22 September 2021

I refer to the referral of 17 August 2021 from NSW Planning, Industry & Environment regarding NSW Government concurrence and referral request CNR-27646 for Wollongong City Council Development Application DA-2021/957 at the street block bound by Crown, Keira, Burelli and Atchison Streets WOLLONGONG for 'Demolition of existing structures, retention of heritage facades, tree removal, excavation for basement car parking and construction of a mixed-use development, comprising three (3) residential towers (shop top housing), one (1) commercial building, retail shops, entertainment facilities (cinema, exhibition/performance space) and a wellness centre (pool, gym, and health services)'. Submissions need to be made to Council by 22 September 2021.

LEVEL - BASEMENT

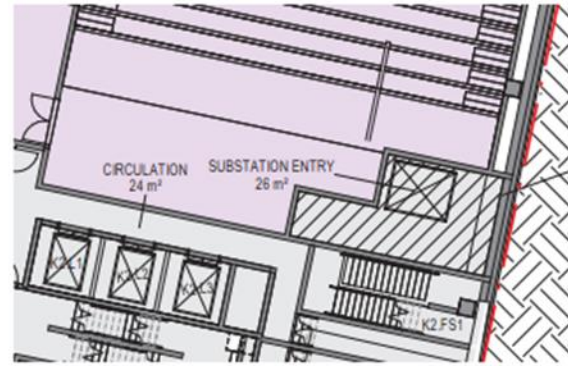
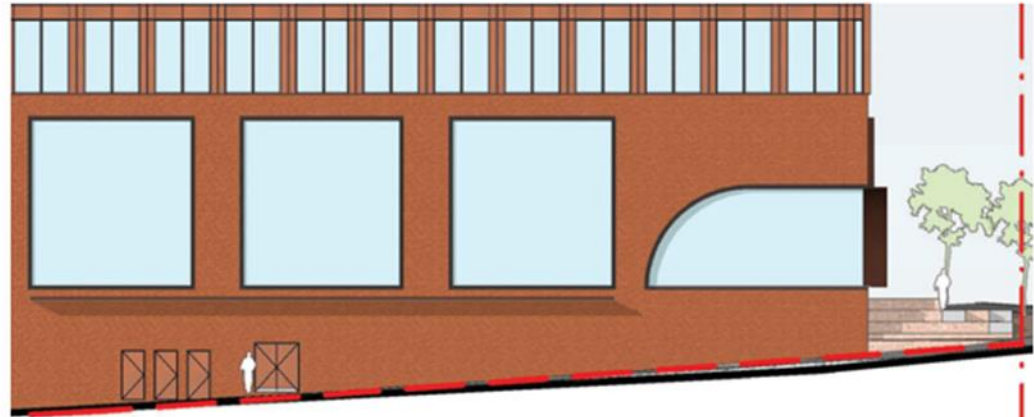
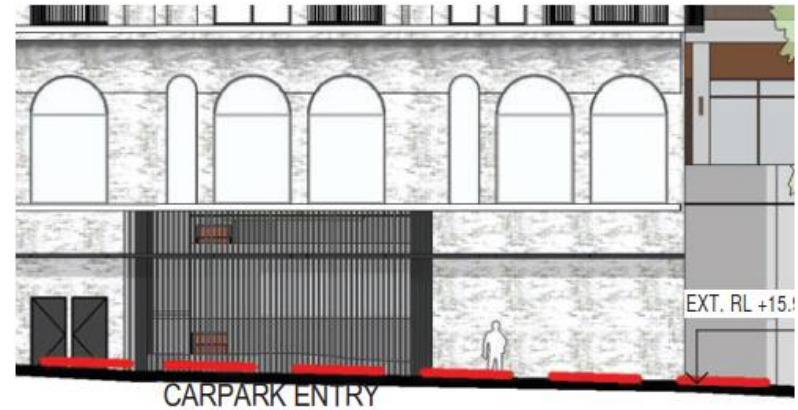
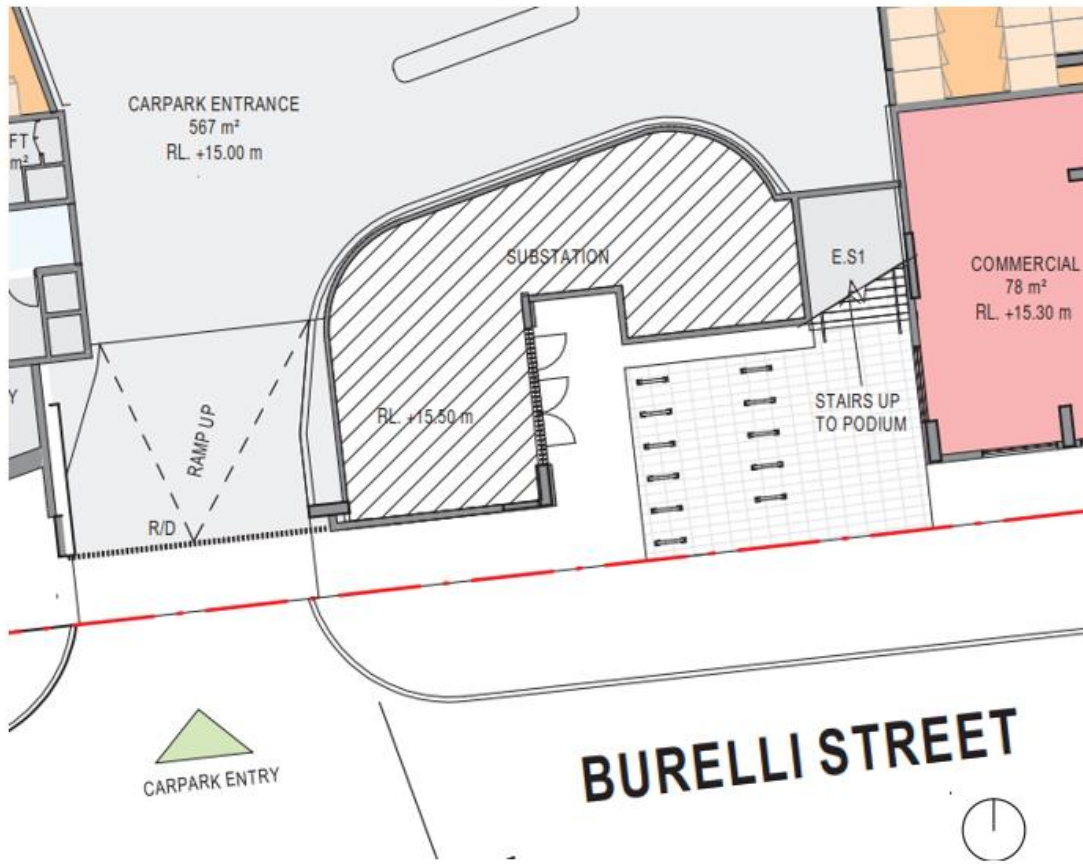
The proposed new indoor substations are shown in the following extract of the Architectural Plans.

From Endeavour Energy's perspective the fact that provision is being made for an indoor substation is a positive. Endeavour Energy's general requirements is for an indoor substation to be at ground level and have direct access from a public street.

Generally it is the Level 3 Accredited Service Provider's (ASP) responsibility (engaged by the developer) to make sure that the substation location and design complies with Endeavour Energy's standards the suitability of access, safety clearances, fire ratings, flooding etc. As a condition of the Development Application consent Council should request the submission of documentary evidence from Endeavour Energy confirming that satisfactory arrangements have been made for the connection of electricity and the design requirements for the substation, prior to the release of the Subdivision Certificate / commencement of works.

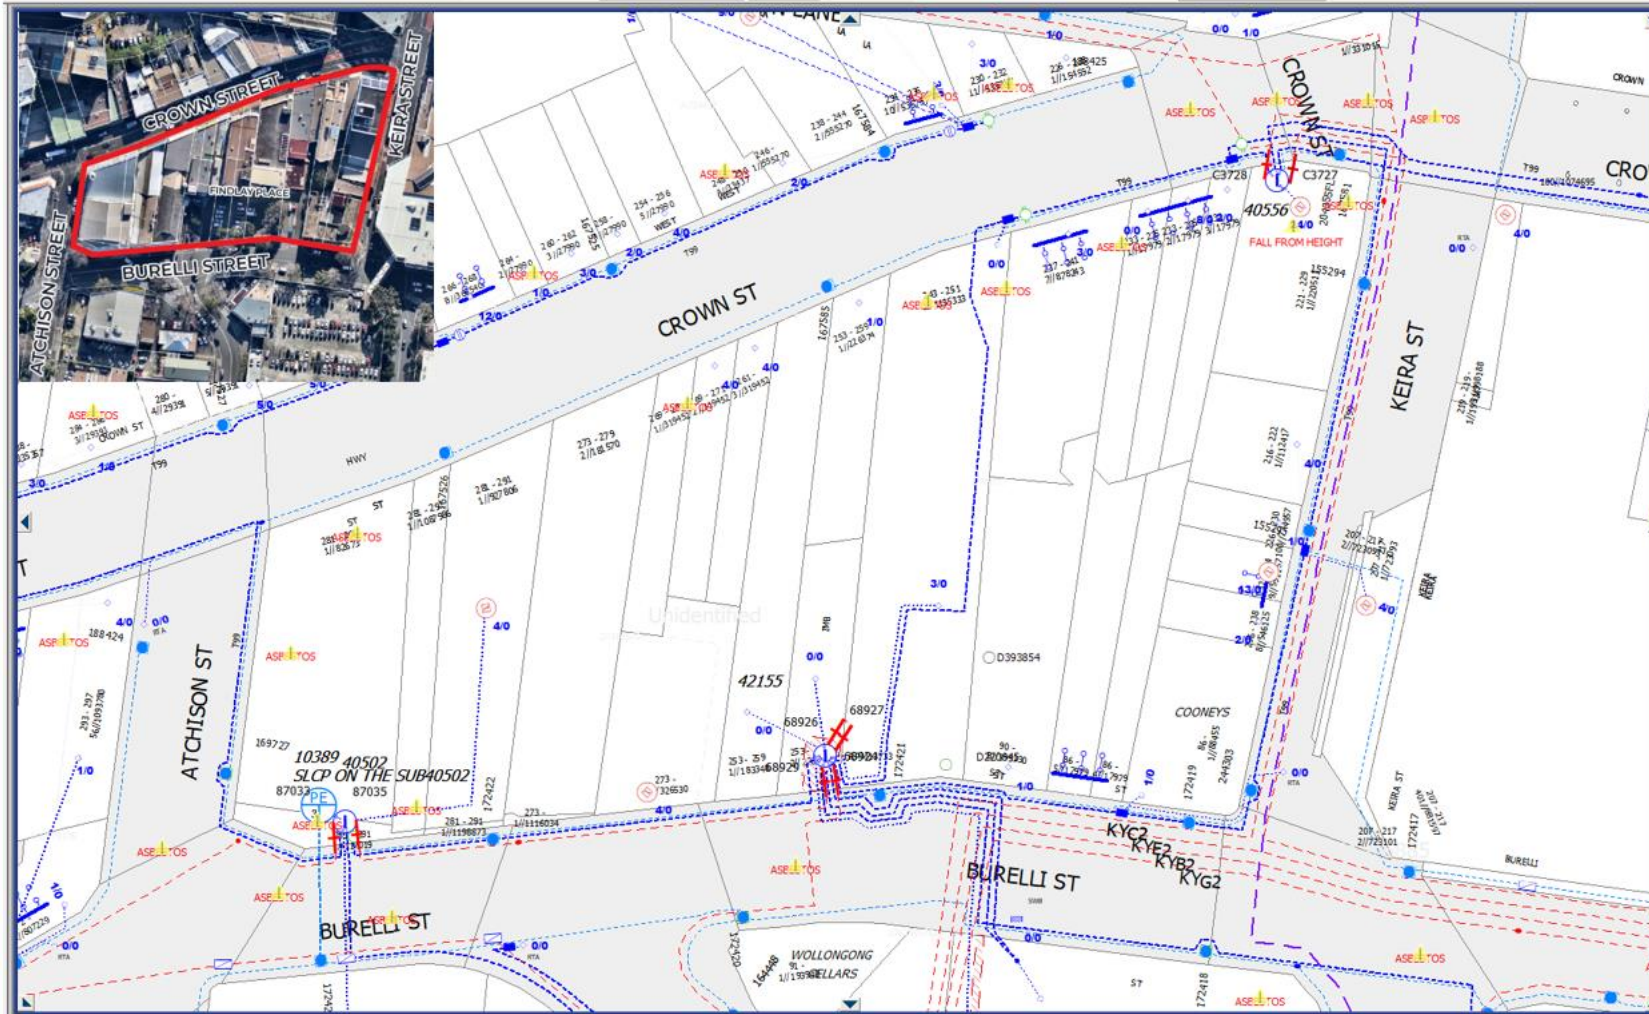
As shown in the below site plan from Endeavour Energy's G/Net master facility model (and extracts from Google Maps Street View) there are:

- Three indoor substations (indicted by the symbol ) with indoor substation no. 42155 held under an easement benefitting Endeavour Energy (indicated by red hatching) with indoor substations no.s 40502 and 40556 being expired leases.
- Low voltage underground cables traversing the site which are not held under easement.
- Low voltage and 11,000 volt / 11 kilovolt (kV) high voltage underground cables to the road verges / roadways.

Although not held under easement or being expired leases, these are protected assets and deemed to be lawful for all purposes under Section 53 'Protection of certain electricity works' of the *Electricity Supply Act 1995* (NSW). Essentially this means the owner or occupier of the land cannot take any action in relation to the presence in, on or over the land of electricity works ie. the electricity infrastructure cannot be removed to rectify the encroachment. These protected assets are managed as if an easement (or in this instance the expired leases) are in place – please refer to the below point 'Easement Management / Network Access'.

In accordance with the attached copy of Endeavour Energy's Mains Design Instruction MDI 0044 'Easements and Property Tenure Rights', and as shown in the following extract of Table 1 – 'Minimum easement widths', the low voltage underground cables (assumed to have no concrete protection unless proven otherwise) requires a 3 metre minimum easement width ie. 1.5 metres to both sides of the centre line of the cable ducts.
